From: BCTAdmin@thameswater.co.uk
Sent: 24 March 2022 10:31
To: Planning
Subject: 3rd Party Planning Application - 22/00747/OUT

Our DTS Ref: 55031
Your Ref: 22/00747/OUT

Re: LAND AT, BICESTER ROAD, KIDLINGTON, KIDLINGTON, OXFORDSHIRE , OX5 2LL

2 Foul Water Indicative Strategy

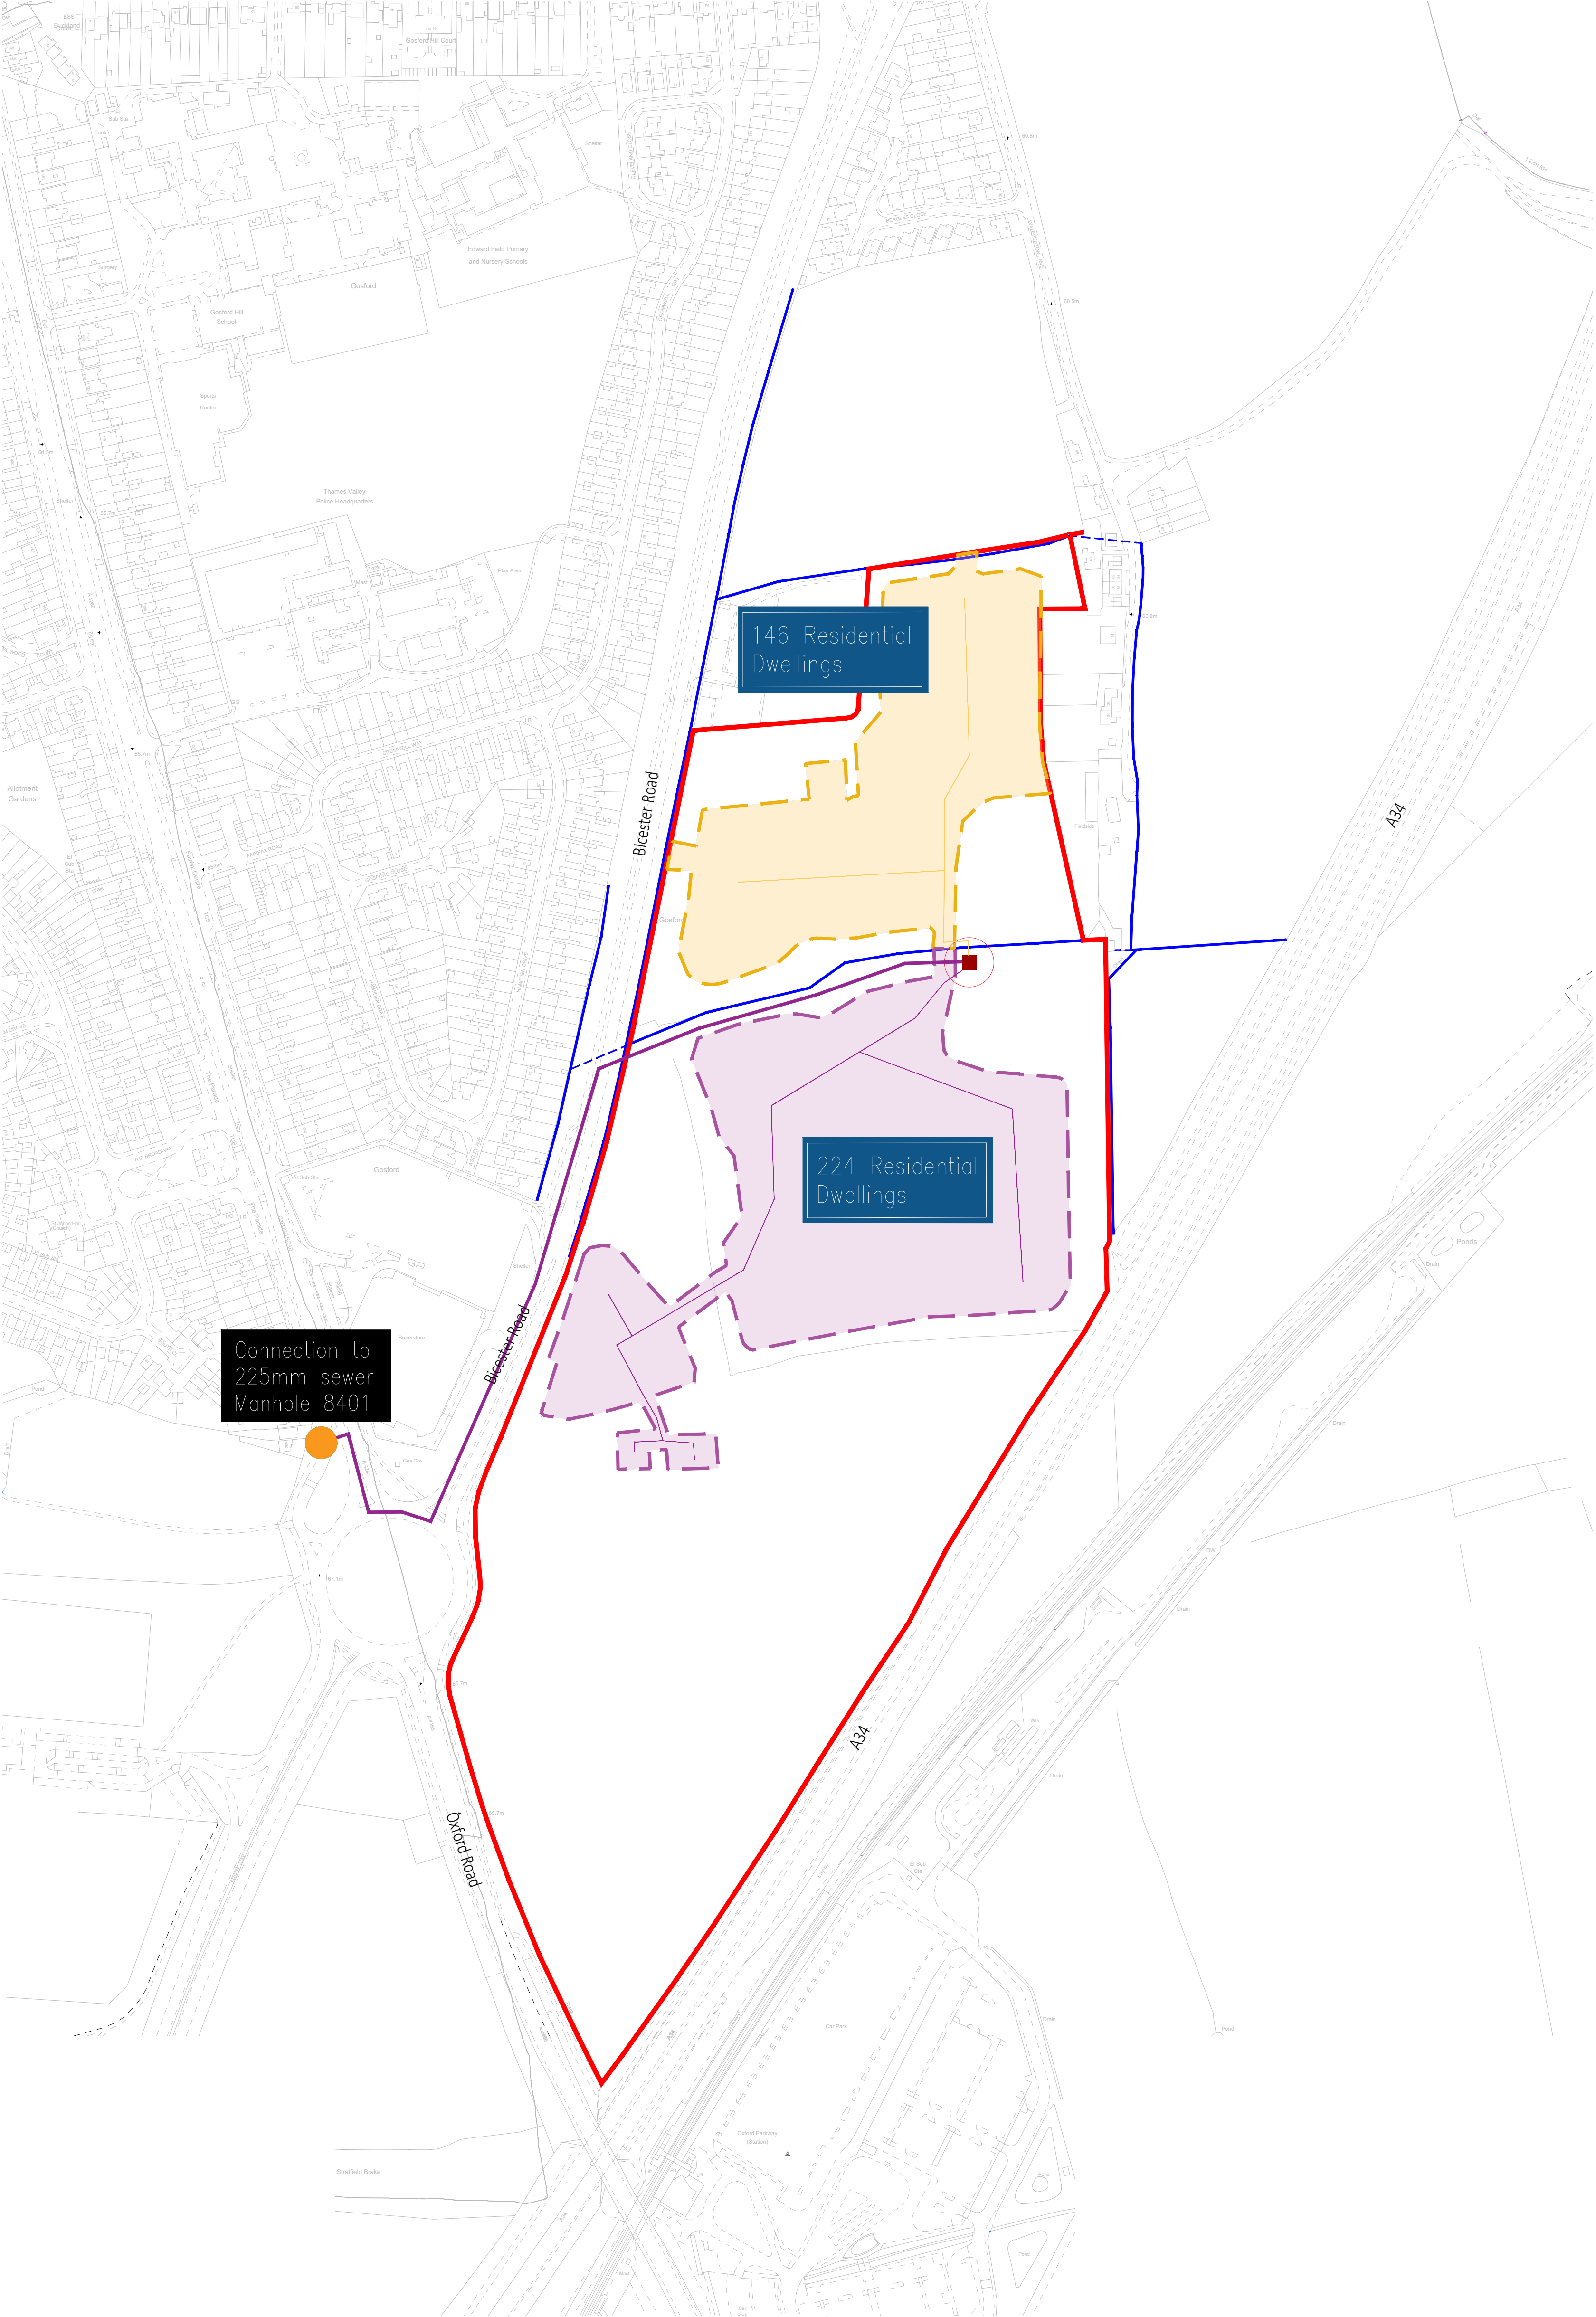
With the information provided, Thames Water has been unable to determine the Foul water infrastructure needs of this application. Thames Water has contacted the developer in an attempt to obtain this information and agree a position for FOUL WATER drainage, but have been unable to do so in the time available and as such, Thames Water request that the following condition be added to any planning permission. "No development shall be occupied until confirmation has been provided that either:- 1. Foul water Capacity exists off site to serve the development, or 2. A development and infrastructure phasing plan has been agreed with the Local Authority in consultation with Thames Water. Where a development and infrastructure phasing plan is agreed, no occupation shall take place other than in accordance with the agreed development and infrastructure phasing plan, or 3. All Foul water network upgrades required to accommodate the additional flows from the development have been completed. Reason - Network reinforcement works may be required to accommodate the proposed development. Any reinforcement works identified will be necessary in order to avoid sewage flooding and/or potential pollution incidents. The developer can request information to support the discharge of this condition by visiting the Thames Water website at thameswater.co.uk/preplanning. Should the Local Planning Authority consider the above recommendation inappropriate or are unable to include it in the decision notice, it is important that the Local Planning Authority liaises with Thames Water Development Planning Department (telephone 0203 577 9998) prior to the planning application approval.

Thames Water advise that a drainage strategy should make clear the location of where the development's foul drainage will be connected to the public sewer either pumped or gravity to make a full capacity assessment.
